**RE: Harnett County Land Use Existing Tank Application # 18-5-44209**

The Harnett County Department of Public Health, Environmental Health Division evaluated the above referenced property at the site designated on the plat/site plan that accompanied your existing tank application. According to your application requesting a 15 x 33 family room addition and a deck addition of 12 x 20. The evaluation was done in accordance with the laws and rules governing wastewater systems in North Carolina General Statute 18A.1950 including related statutes and Title 15A, Subchapter 18A, of the North Carolina Administrative Code, Rule.1950 and related rules. *Please note that your septic tank lid was not uncovered and the seal broken at the time of the visit and an additional \$25.00 will be incurred for the return visit as well as a possible revision fee should you change your site plan.*

Based on the criteria set out in Title 15A, Subchapter 18A, of the North Carolina Administrative Code, Rules .1950, the evaluation indicated that the site is **UNSUITABLE** for. Therefore, your request for an existing tank is **DENIED**. The site is denied based on the following:

DISTRICT PA-30 USE 15x33 family room addition and 12x20 deck.

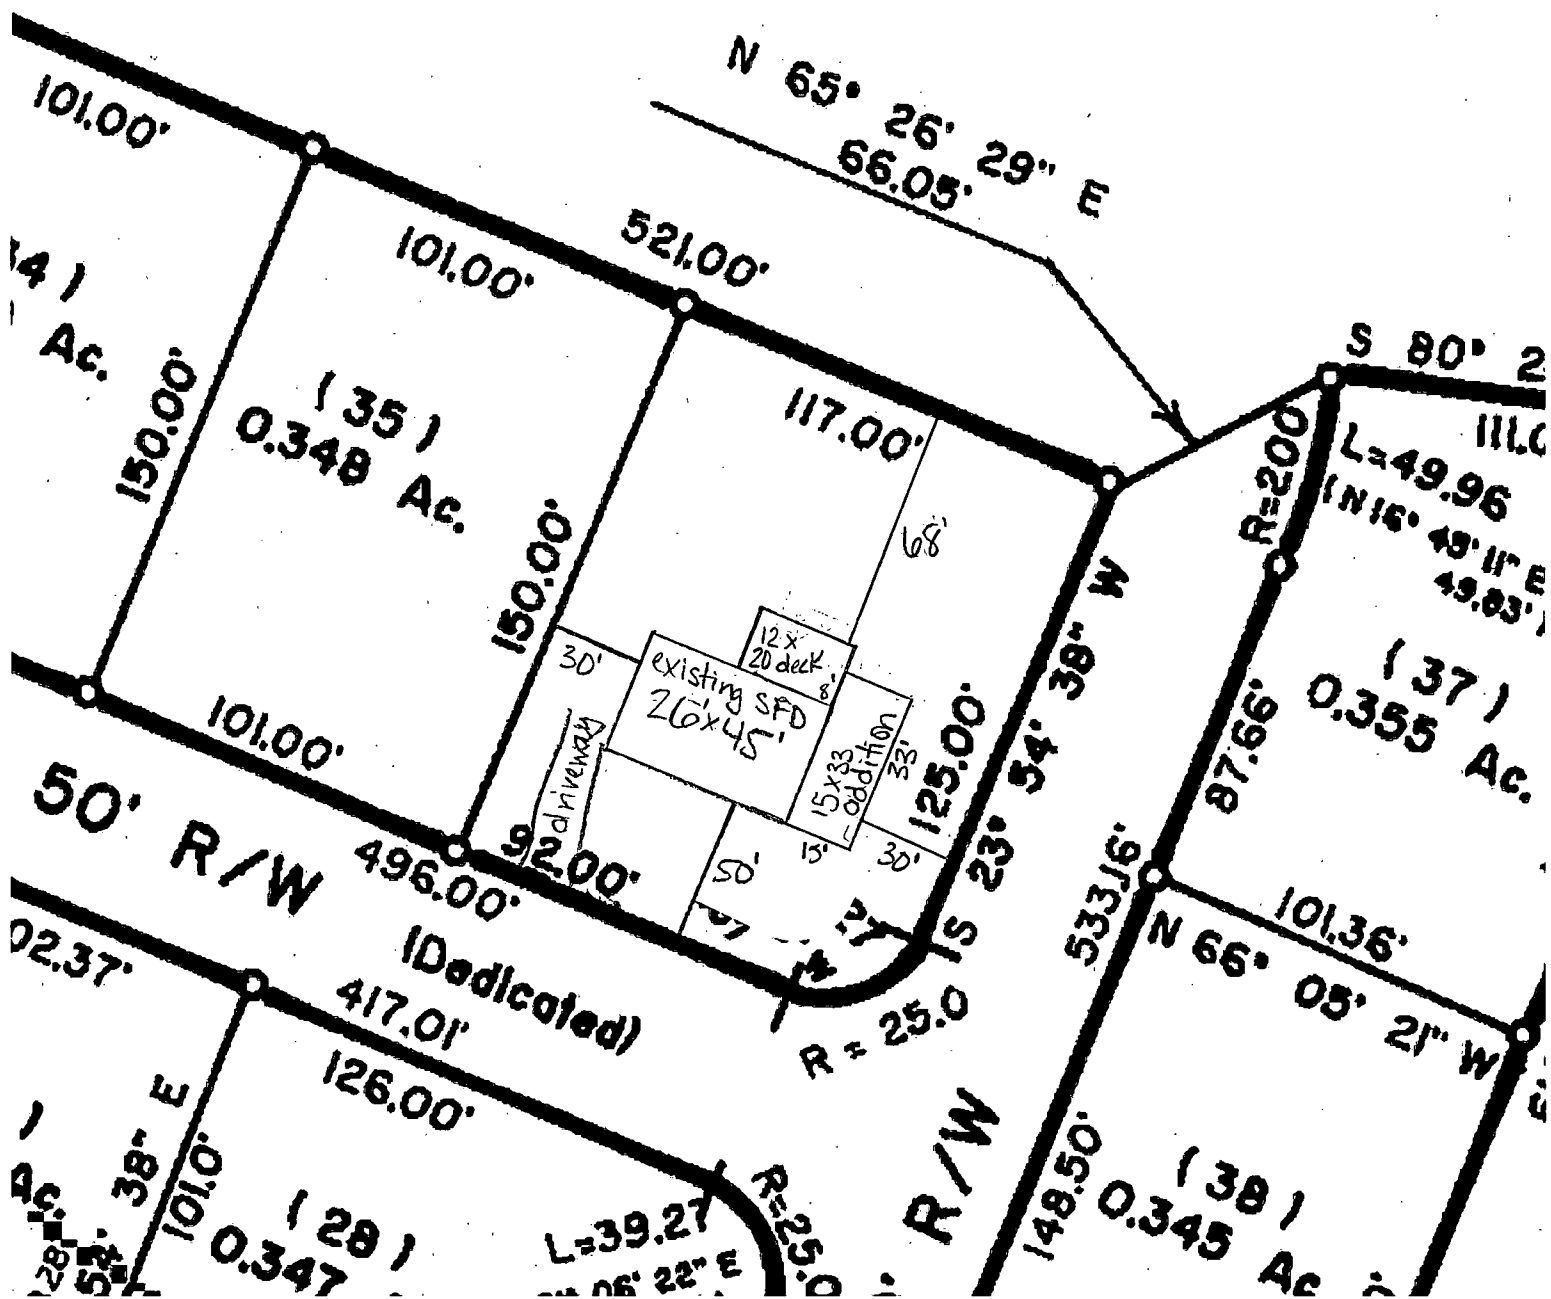
- 15A NCAC 18A.1950a {16} - Any swimming pool must be 15' from any part of septic system.**
- 15A NCAC 18.1945{b} - Each lot shall have original septic system plus repair area.**
- 15A NCAC 18A.1950 {10} - Any building to be 5' from septic tank and/or from drain line. (This pertains to the proposed deck)**
- 15A NCAC 18A.1950{c} - Nitrification fields and repair areas shall not be located under paved areas or areas subject to vehicular traffic.**
